WEST SUSSEX COUNTY COUNCIL CONSULTATION

TO:	Arun District Council FAO: Michael Eastham
FROM:	Highways, WSCC – Tim Townsend
DATE:	12 th June 2018
LOCATION:	Land at Bridge Cottage and The Old Cottage, Lidsey Road, Lidsey, PO22 9PH
SUBJECT:	AL/20/18/OUT Outline application with all matters reserved for the demolition of 2 No. dwellings & associated outbuildings & the erection of up to 27 No. dwellings, of which 30% will be affordable, with associated open space & access. This application is a Departure from the Development Plan.
DATE OF SITE VISIT:	30 th May and 4th June 2018
RECOMMENDATION:	☒ Advice ☒ Objection ☐ Modification ☐ No Objection ☒ More Information ☐ Refusal
S106 CONTRIBUTION TOTAL:	£TBA

This is the WSCC highways and transport response to the above outline planning application with all matters reserved for the demolition of 2 No. dwellings & associated outbuildings & the erection of up to 27 No. dwellings, of which 30% will be affordable, with associated open space & access.

Figure 4.1 – Illustrative Site Plan

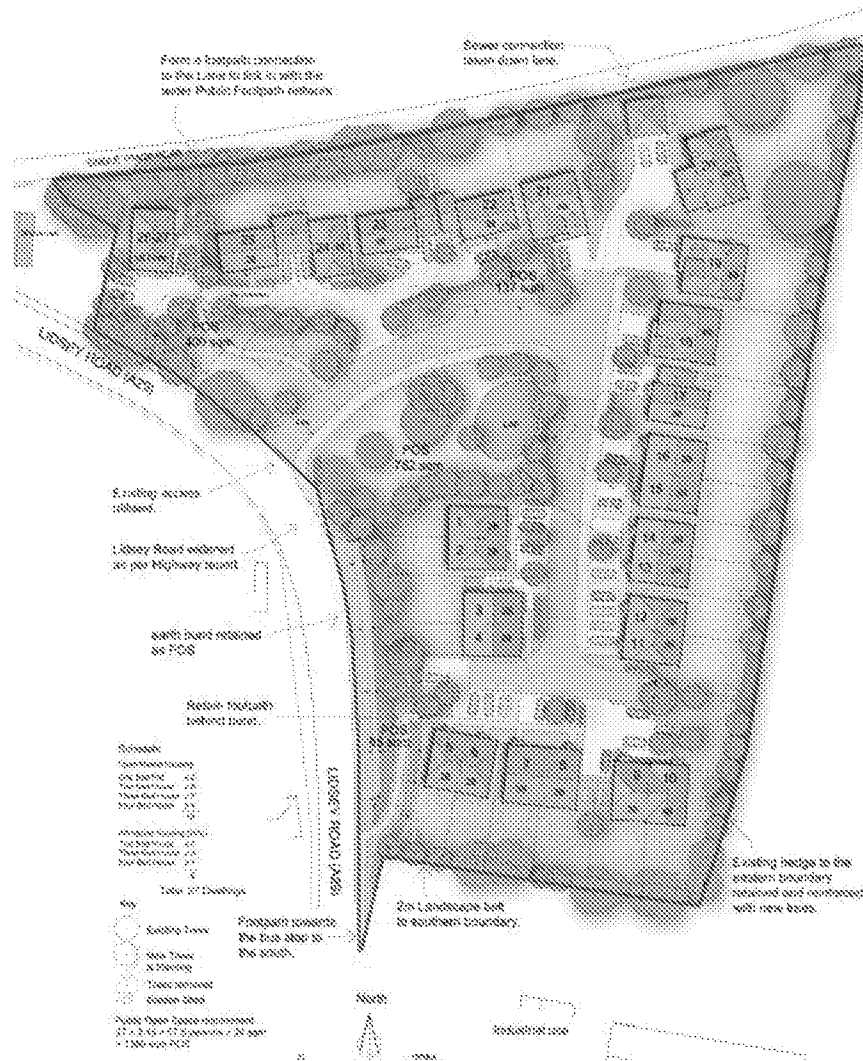
The internal layout is shown indicatively on drawing 1749-02B. As submitted, it would not be suitable for adoption under S38 given lack of suitable service margins. Also, it is not known what form of surface water drainage is proposed for the site which might itself dictate whether the layout can or can't be adopted.

With regard to access by refuse and fire appliances, the access drive shown to plots 22-27 might need widening as in places it looks slightly restrictive (particularly adjacent to plots 25-27). As such, this would have to be considered further at any RES/DOC stage.

Project		
OLD COTTAGE LIDSEY		
New Access Design		
Drawn	Date	Scale (at A3)
TE	19/07/2018	1:500
Doc no.	Revision No.	
OCL/SR/701	C

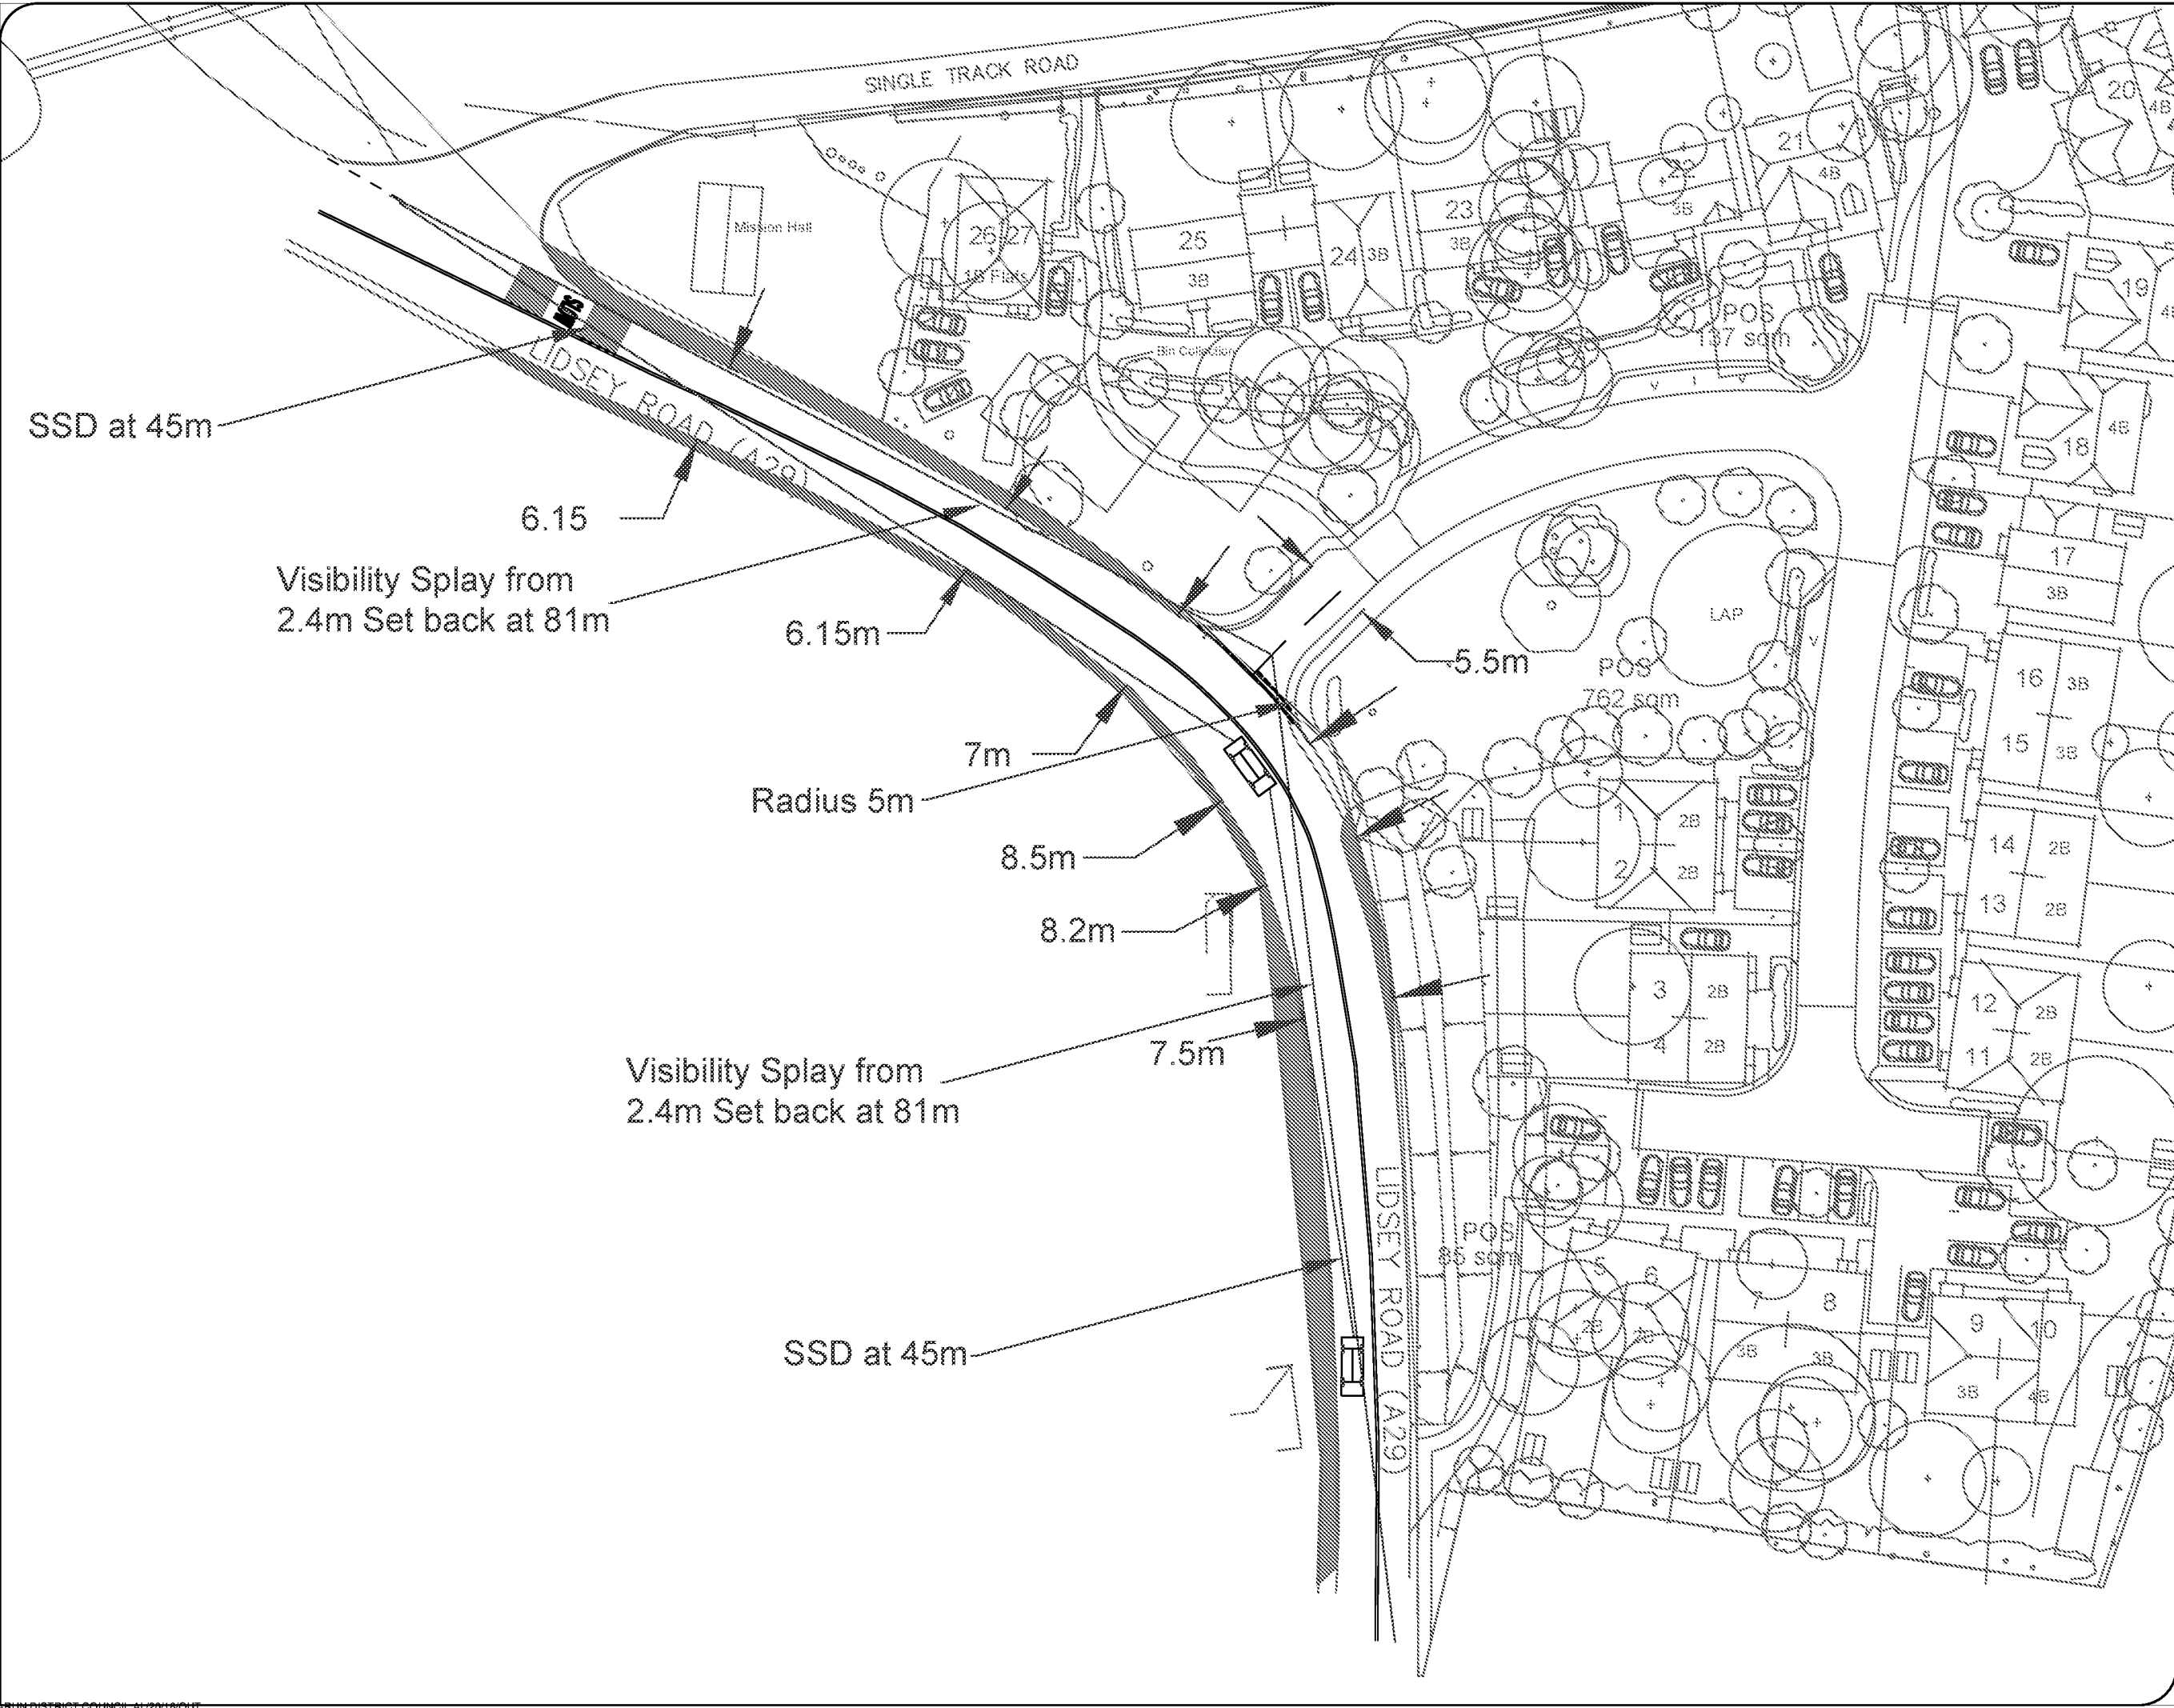
As mentioned above, vehicular access is shown directly off the A29 on the apex of a bend in the road. The access measures 4.8m wide with what appears to be 5.0-6.0m bellmouth radii (this should be clarified and marked-on a plan). Visibility splays are taken from a 2.4m 'x' distance with major road ('y'), with the applicant's Transport Consultant stating that splays of 106m in the leading traffic direction can be provided - looking west from the access - (98m scales on the plan) and 150m in the trailing direction - looking south - (79m scales on the plan). Forward visibility (i.e. that required for drivers of vehicles turning right and left into the site and corresponding visibility for drivers already on Lidsey Road coming-across them - from both north and south) is stated as being 81m (although approximately 60m scales from the drawing between a right turning vehicle and driver of a vehicle travelling southbound). No northbound forward visibility splay is shown for vehicles driving northwards coming across a vehicle turning right into the site.

Given the lack of clarity including lack of marked-on dimensions and visibility splays - it is not known what can actually be provided - both on and off-site. For the CHA to consider the matter further, the above matters should be attended to - a summary of which is provided below (other requirements are summarised elsewhere in this report under relevant sections):

- The dimensions of bellmouth radii of new junction
- The achievable visibility splays taken from 2.4m 'x' distance with dimensions marked-on
- The forward visibility both for vehicles travelling north AND south encountering a vehicle waiting to turn into the site with dimensions
- Dimensions of carriageway at and on the approach to the site entrance (and site entrance itself)

(All the above to be shown on a revised plan).
